KITITAS COUNTY

MEMORANDUM

TO: All Staff
FROM: Public Works Plan Review Team
DATE: May 28, 2025
SUBJECT: LP-25-00003 Brown Road Estates LLC

**1601 BROWN ROAD PLAT  
PART OF SECTIONS 3 & 4, T. 17 N., R. 18 E., W.M.  
KITITAS COUNTY, WASHINGTON  
- PRELIMINARY PLAT -**

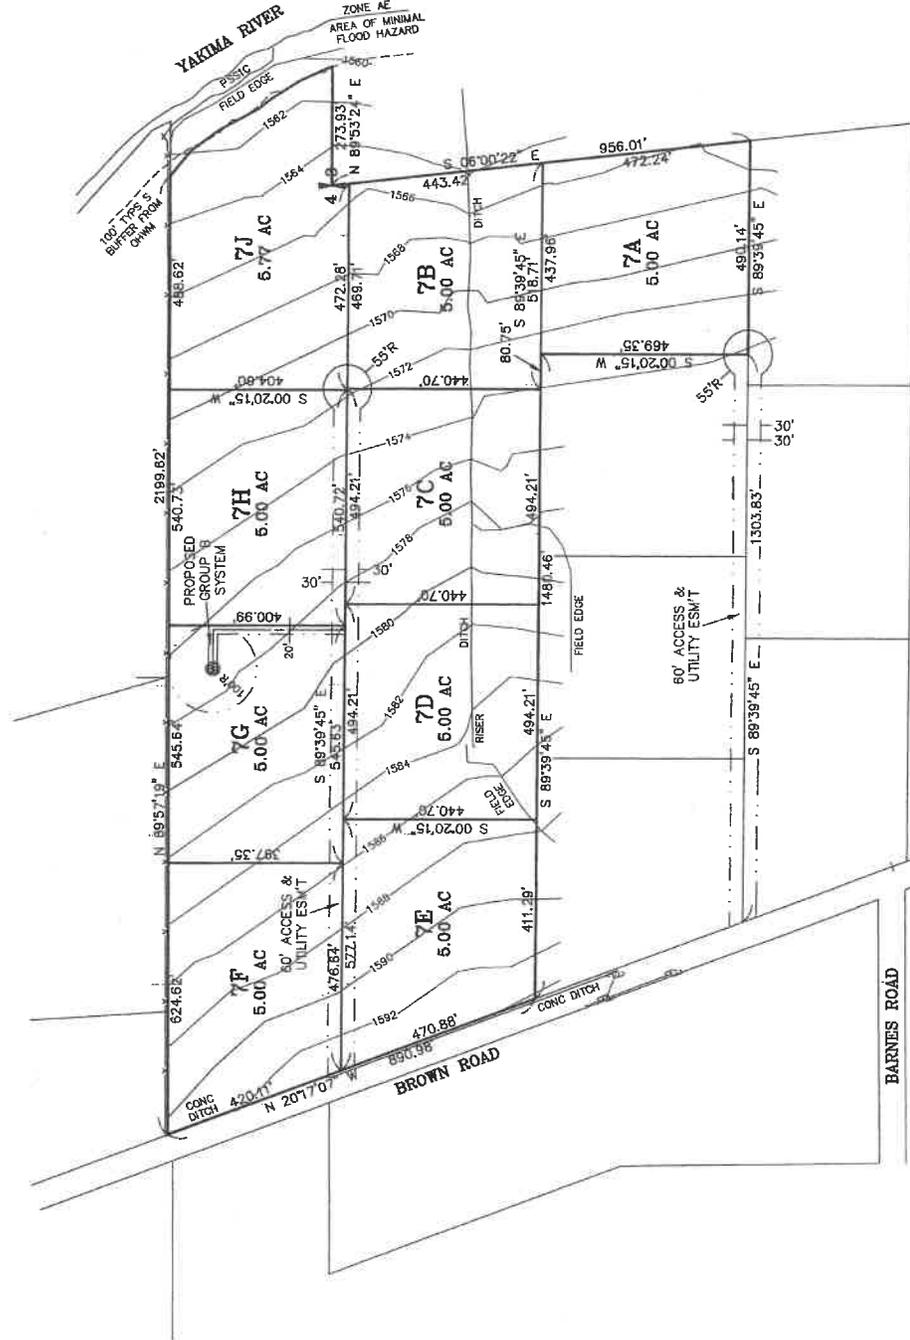
ENGINEERING	<p>There is already an existing grading permit associated with this project (GP-25-00002).</p> <p>Road certification will be required prior to final plat. (CBP)</p>
SURVEY	<p>The following elements will need to be added to meet the requirements of a Preliminary Plat. This does NOT address comments for Final.</p> <ol style="list-style-type: none"> 1. Survey legend needs to be shown. 2. Record Land descriptions need to be shown, matching subdivision guarantee of record. 3. Basis of bearing needs to be addressed. 4. Engineer of Record needs to be shown 5. Adjacent subdivisions need to be labeled. 6. Easements shown shall include notation if they are existing or proposed. 7. Brown Road needs to include width, ownership and surfacing. <p>OF NOTE</p>

The requirement to show existing lot lines has been excluded as all parcels are under the same ownership and would just clutter the map further. (JT)
TRANSPORTATION CONCURRENCY	A transportation concurrency management application will be required for this project per KCC 12.04.02.020 (KAH)
FLOOD	<p>A portion of parcel #618133 is located in the FEMA identified 100-year floodplain and floodway. Please be advised that the floodway is highly restricted and any development within the floodway must be permitted through a floodplain development permit and must demonstrate no rise of 100-year flood elevations before being permitted. No new or substantially improved residences are allowed within the Floodway.</p> <p>If possible, any future development should remain outside of the floodplain in order to reduce risk and avoid mandatory flood insurance purchase requirements. All activities within the floodplain must be permitted through the floodplain development permit process and follow the regulations within KCC 14.08.</p> <p>In accordance with KCC Chapter 14.08.220, all subdivisions as well as new development shall:</p> <ol style="list-style-type: none"> 1. Be consistent with the need to minimize flood damage. 2. Have public utilities and facilities such as sewer, gas, electrical, and water systems located and constructed to minimize flood damage. 3. Have adequate drainage provided to reduce exposure to flood damage. 4. Where base flood elevation data has not been provided or is not available from another authoritative source, it shall be generated for subdivision proposals and other proposed developments containing greater than 50 lots or 5 acres (whichever is lesser) and shall be included as part of the application and shall be noted on the final mylar. 5. All subdivisions shall show on the face of both the preliminary and final plat, for either short or long plats, the boundary of the 100-year floodplain and floodway. <p>(SC)</p>
